2024/0807

112 Rotherham Road, Smithies, Barnsley, S71 1UT

Erection of single storey front and rear extensions, and installation of cladding to existing front elevation.

PROPOSED GROUND FLOOR PLAN
SCALE 1:100 AT A3

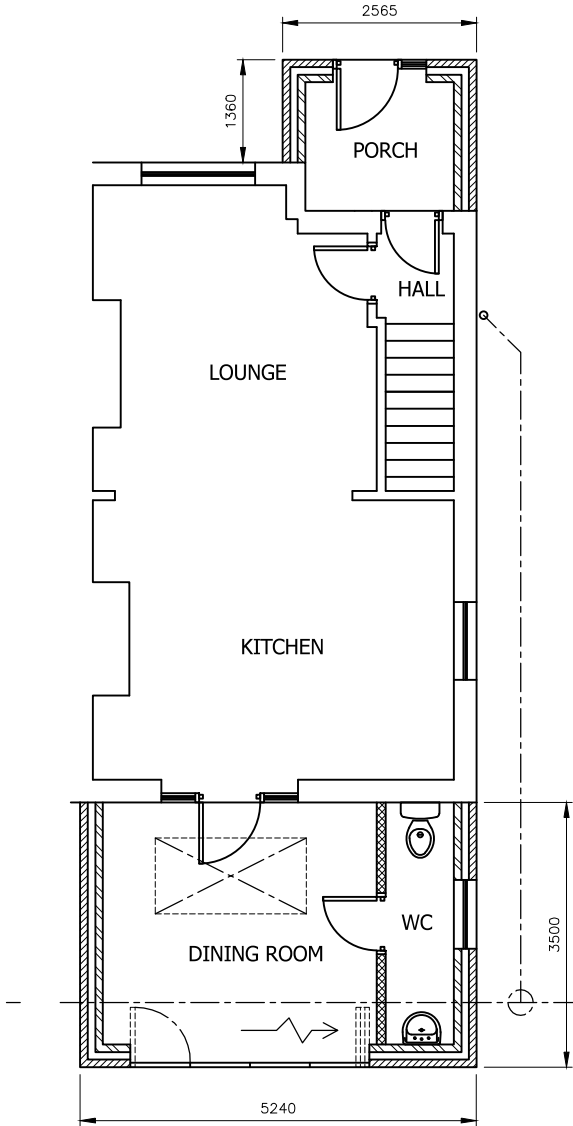
The proposed front extension would adopt a relatively modest scale, including a restrained forward projection and roof height, and would be positioned on the southernmost side of the front elevation of the application property which is set back from the party boundary with 114 Rotherham Road and to the north of 110 Rotherham Road. The proposed front extension is therefore unlikely to result in significantly increased levels of overshadowing. This weighs moderately in favour of the proposed development.

The proposed rear extension would adopt a relatively modest scale, including a restrained rearward projection and roof height, and would replace a smaller existing conservatory. The extension would expand the entire width of the application property and would be positioned to the south and south-east of the adjoining property and curtilage. It is therefore acknowledged that some overshadowing could occur, especially as the extension would exceed the 45-degree rule (which is applied to assess and limit the extent of overshadowing and loss of outlook), contrary to the House Extensions and Other Domestic Alterations SPD. However, the extent in which the extension would exceed to 45-degree rule would be minimal. Moreover, this extension would fall within the parameters of larger home extension development as outlined within the Town and Country Planning (General Permitted Development Order) 2015 (as amended). This allows homeowners to erect a single storey rear extension with a rearward projection of up to 6 metres on a semi-detached property without the need for planning permission where no neighbouring properties object. Neighbouring properties were notified of this application and no objections were received. The proposed rear extension is therefore unlikely to result in significantly increased levels of overshadowing or reduced outlook. This weighs moderately in favour of the proposed development.

PROPOSED FRONT ELEVATION
SCALE 1:100 AT A3

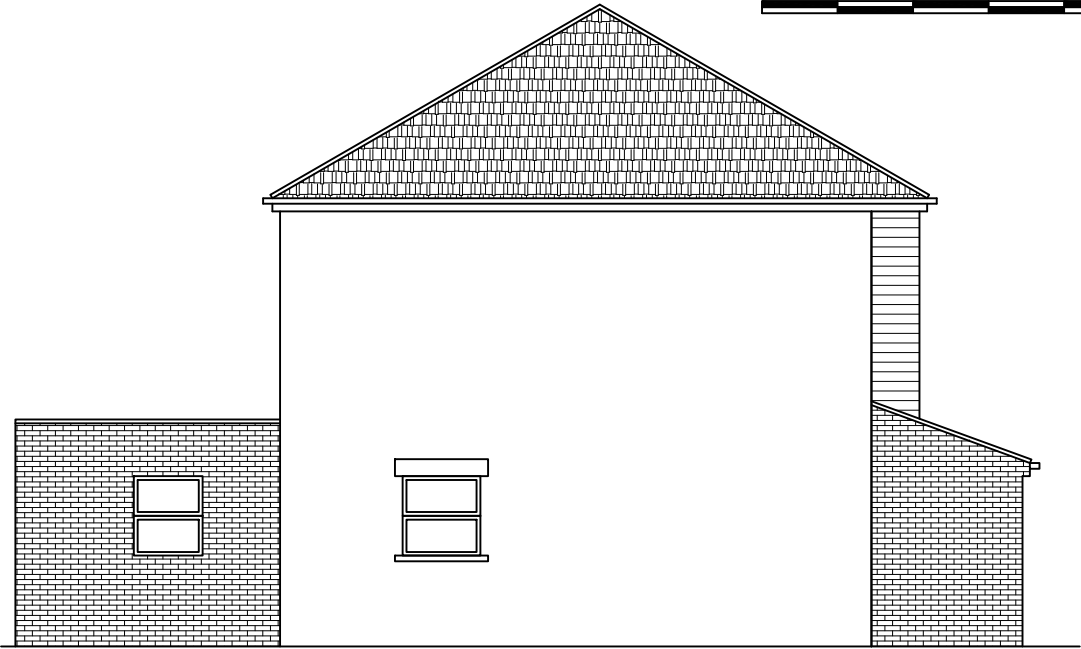
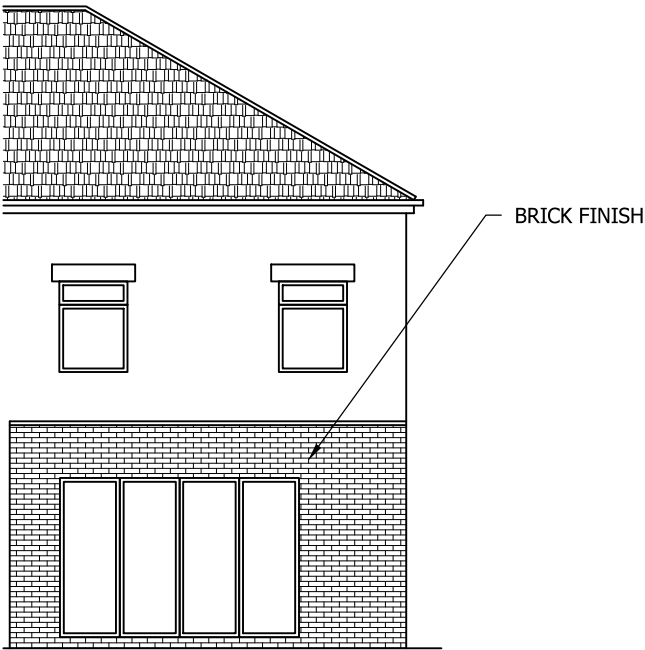
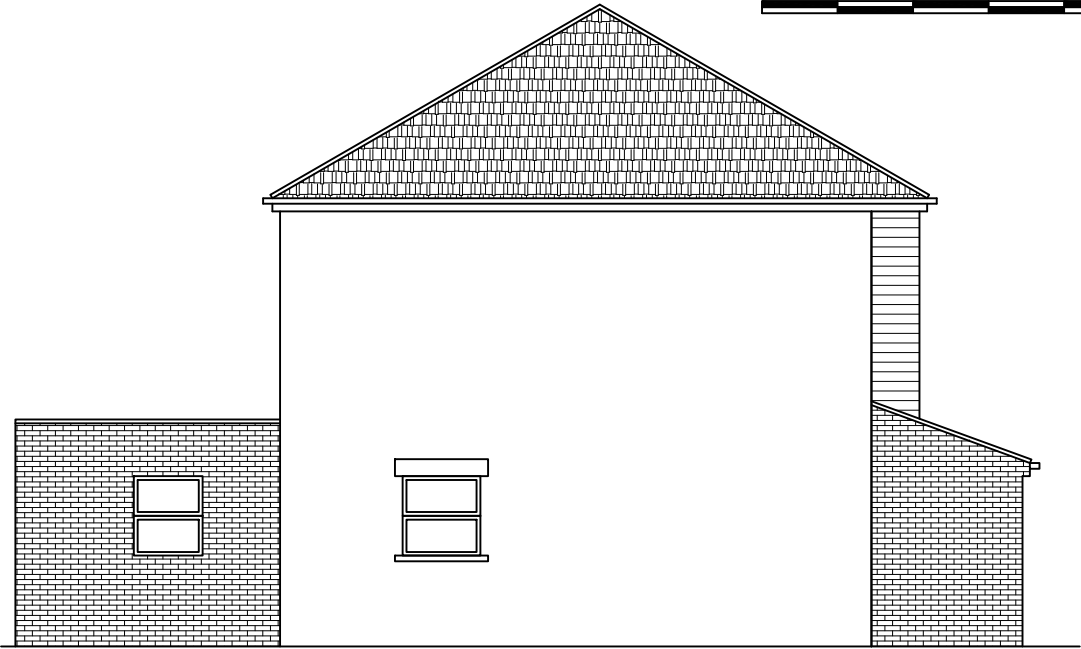
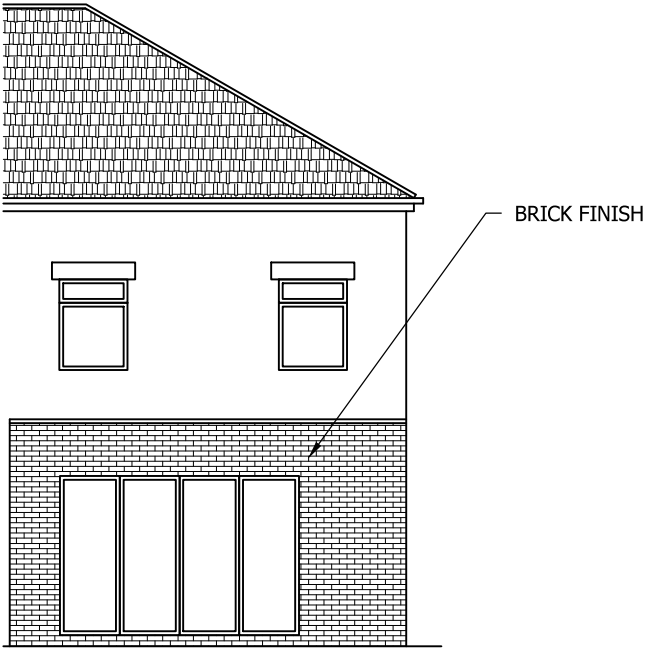
During the application process, the proposed development was amended to reduce the amount of cladding in the interest of the visual amenities of the locality.

The proposed grey upvc shiplap cladding would be limited to the northernmost side of the front elevation of the application property at first floor level. During the application process, the amount of cladding was reduced to address visual amenity concerns. The revised proposal would appear much more subdued and would not drastically alter the external appearance of the application property. Moreover, the street scene of Rotherham Road is varied, characterised by two-storey detached and semi-detached dwellings of varying scale and appearance, including pitched and hipped roofs, and flat roofs with distinctive parapets. The street scene material palette includes a mix of brickwork, stonework, render, external painting and upvc cladding. The proposed cladding would therefore not be incompatible with the character of the street scene and would not significantly alter or detract from it. This weighs moderately in favour of the proposed development.

PROPOSED REAR ELEVATION
SCALE 1:100 AT A3

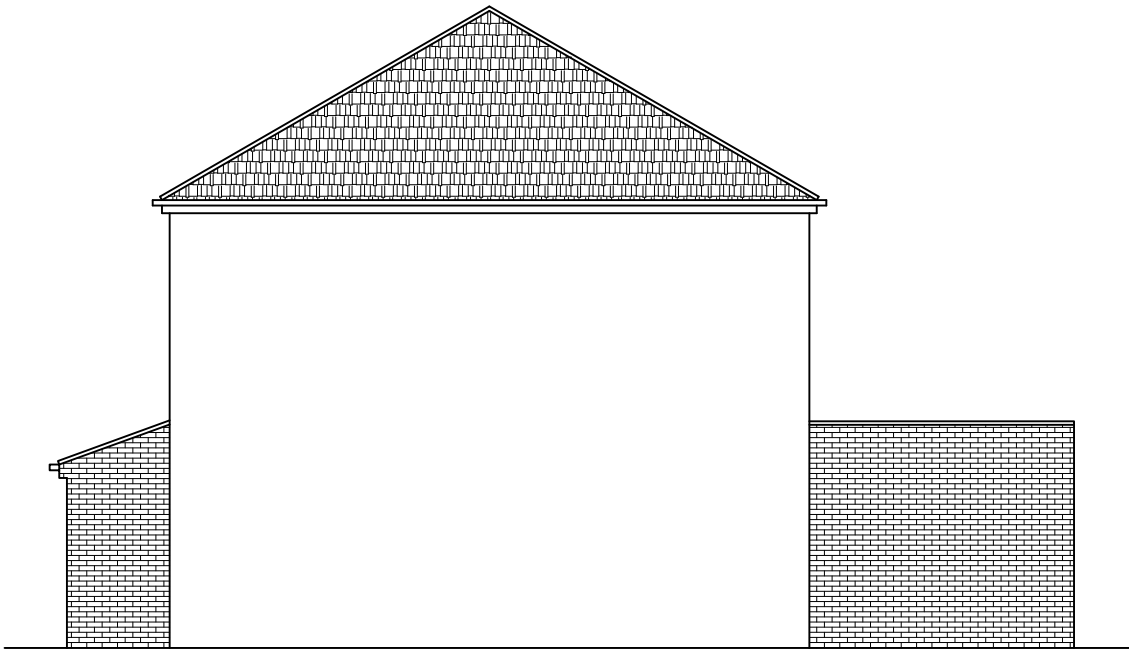
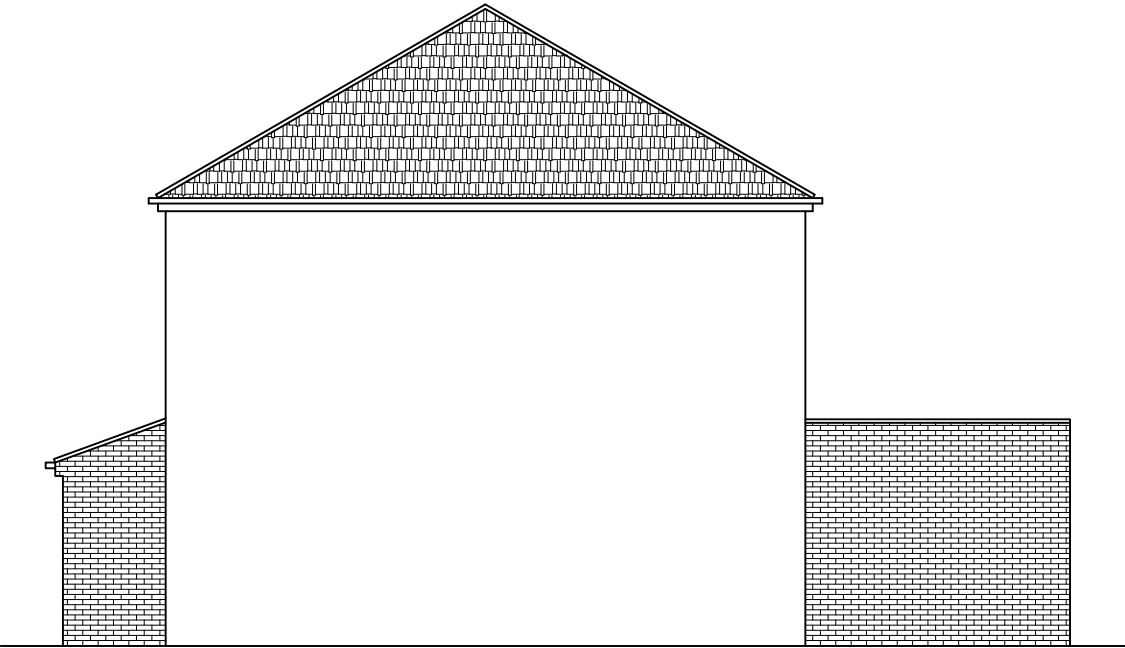
Windows would be limited to the rear and south-east side elevations of the proposed rear extension. The rear-facing windows would face into the application site and away from surrounding properties. The side-facing window would face towards the side elevation of an extension to the rear of 110 Rotherham Road. Whilst this window would be secondary, it would serve a WC. Therefore, this window will be conditioned to be obscure glazed in the interests of the residential amenities of the occupant(s) of the application and adjacent neighbouring properties, in accordance with Local Plan Policy GD1. Subject to conditions, this weighs moderately in favour of the proposed development.

The proposed rear extension would adopt a brick finish and a flat roof, and although a flat roof is not preferred, the extension would not be prominently visible from the surrounding public realm and would therefore not significantly alter nor detract from the character of the street scene. The brick finish is acceptable. This weighs moderately in favour of the proposed development.
